**RE: Valle Prado Subdivision, Units 4 and 5
Tr 6, The Trails Unit 3A
Drainage Report Stamp Date: 1/18/19
Grading Plan Stamp Date: 1/18/19
Hydrology File: C09D011**

Based on the submittal received on 1/18/19 the above-referenced Drainage Report and Grading Plan cannot be approved until the following are corrected:

EXHIBIT C
PHASE 4 GRADING PLAN

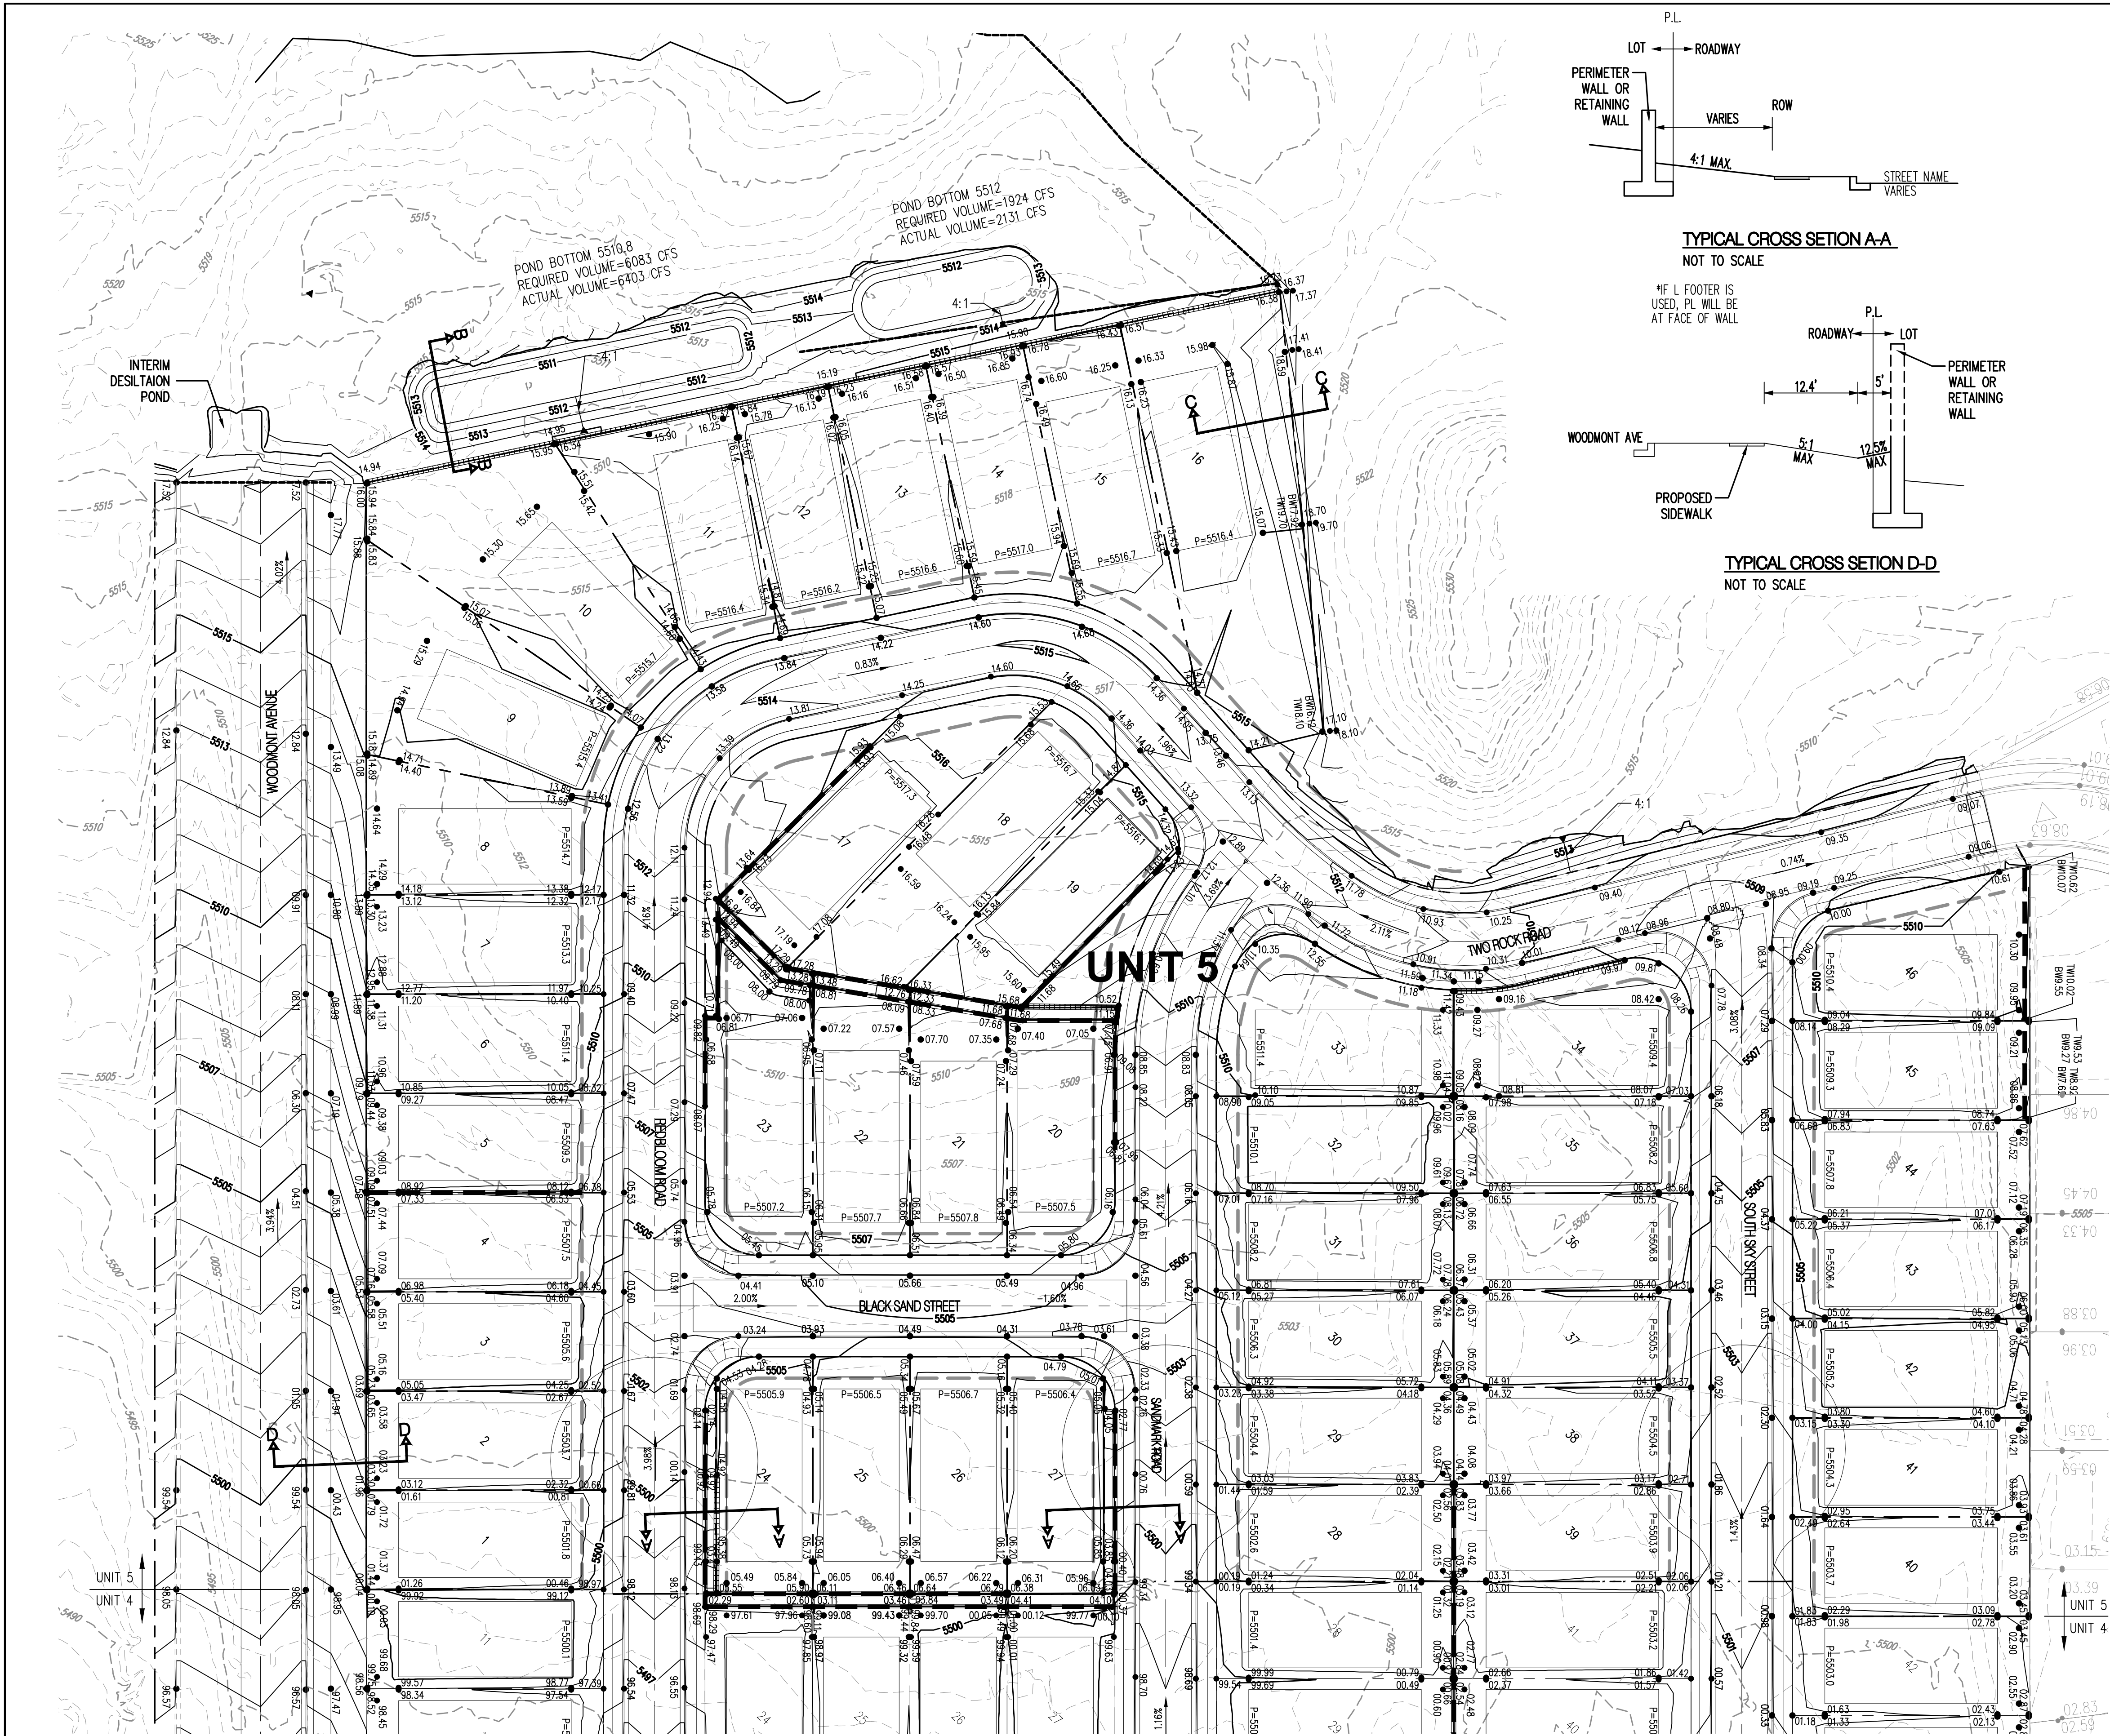
3. Please increase the density of existing and proposed contour labels along the external boundaries. The slope indicators appear to be reversed along the 4:1 tie-in slope.

4. Provide written and signed permission from the owner of Tract OS-2 for the grading on their property (along the north side of Valle Prado Unit 5). If the retaining wall behind lots 10-16, Unit 5 will encroach, you should get this permission as well.

11. Include a typical lot grading detail on the Grading Plan presumably showing that all of the backyards that drain to the streets via sideyard swales.

EXHIBIT D
PHASE 5 GRADING PLAN

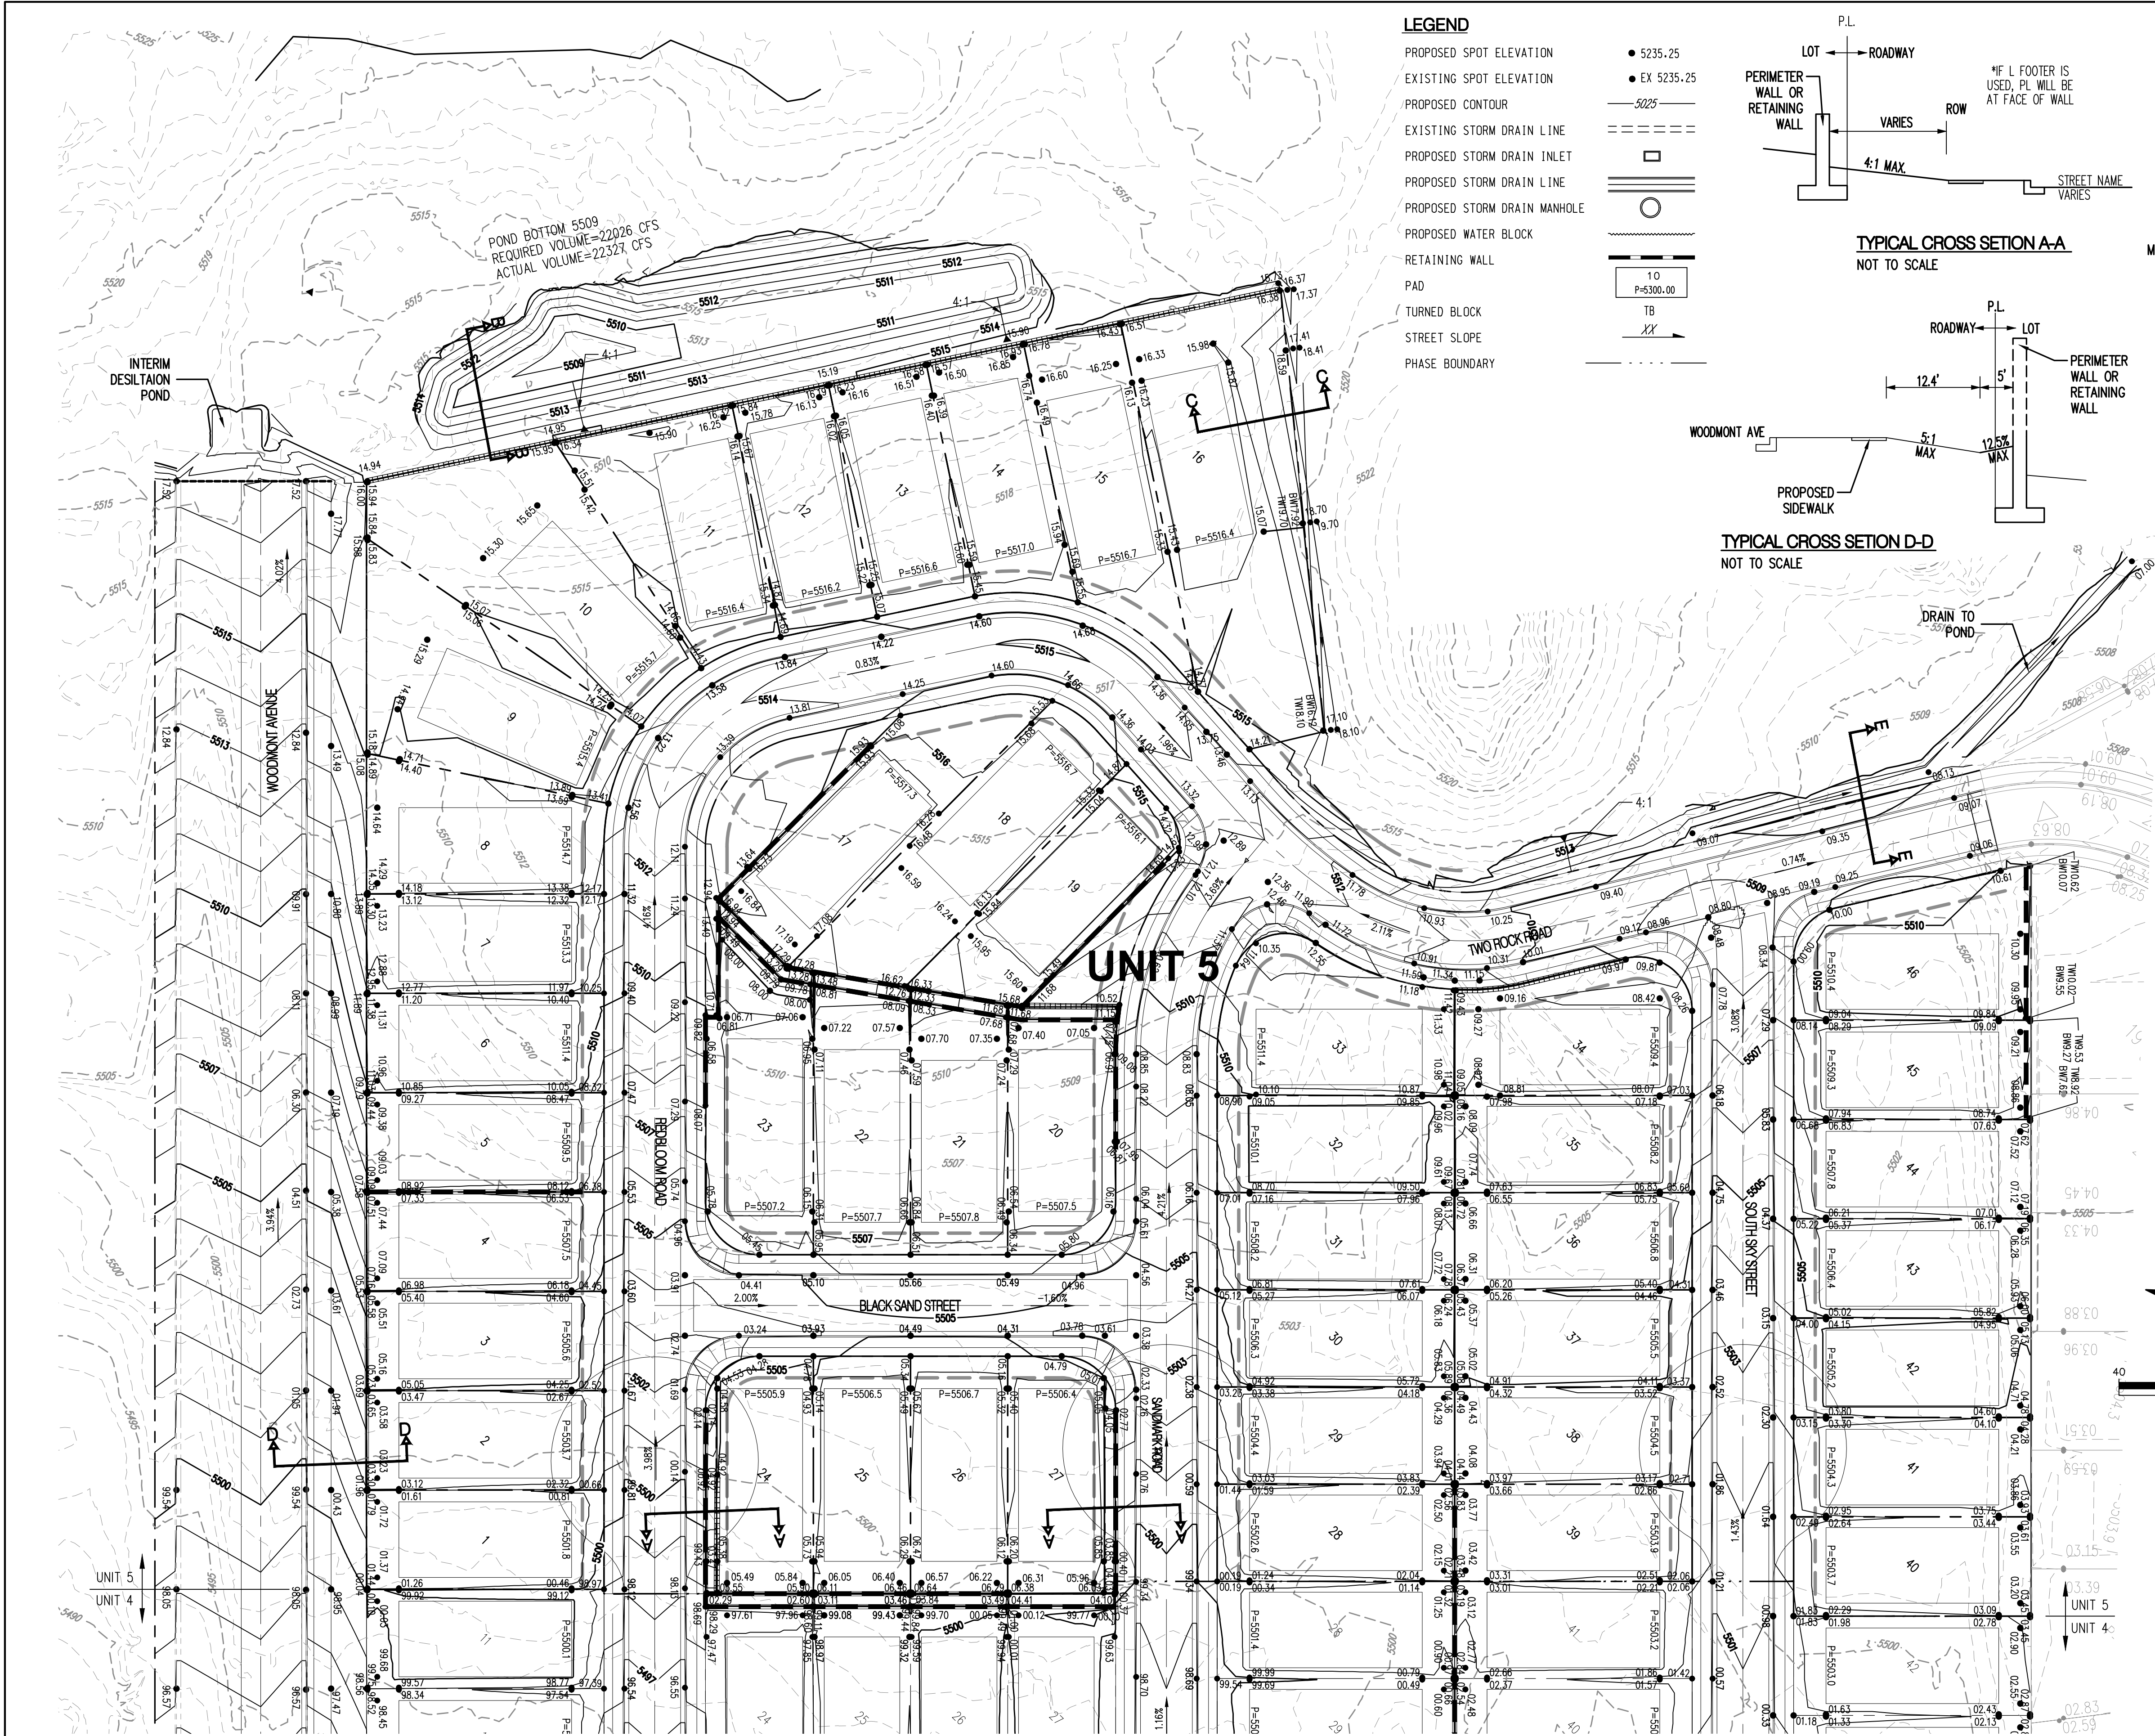
5. How will Lot 16, Unit 5 convey flows from Tract OS-2 to the public road? Provide a detail or section. How will this property be protected from offsite flows and does it need a cross lot drainage easement or separate tract for the runoff?
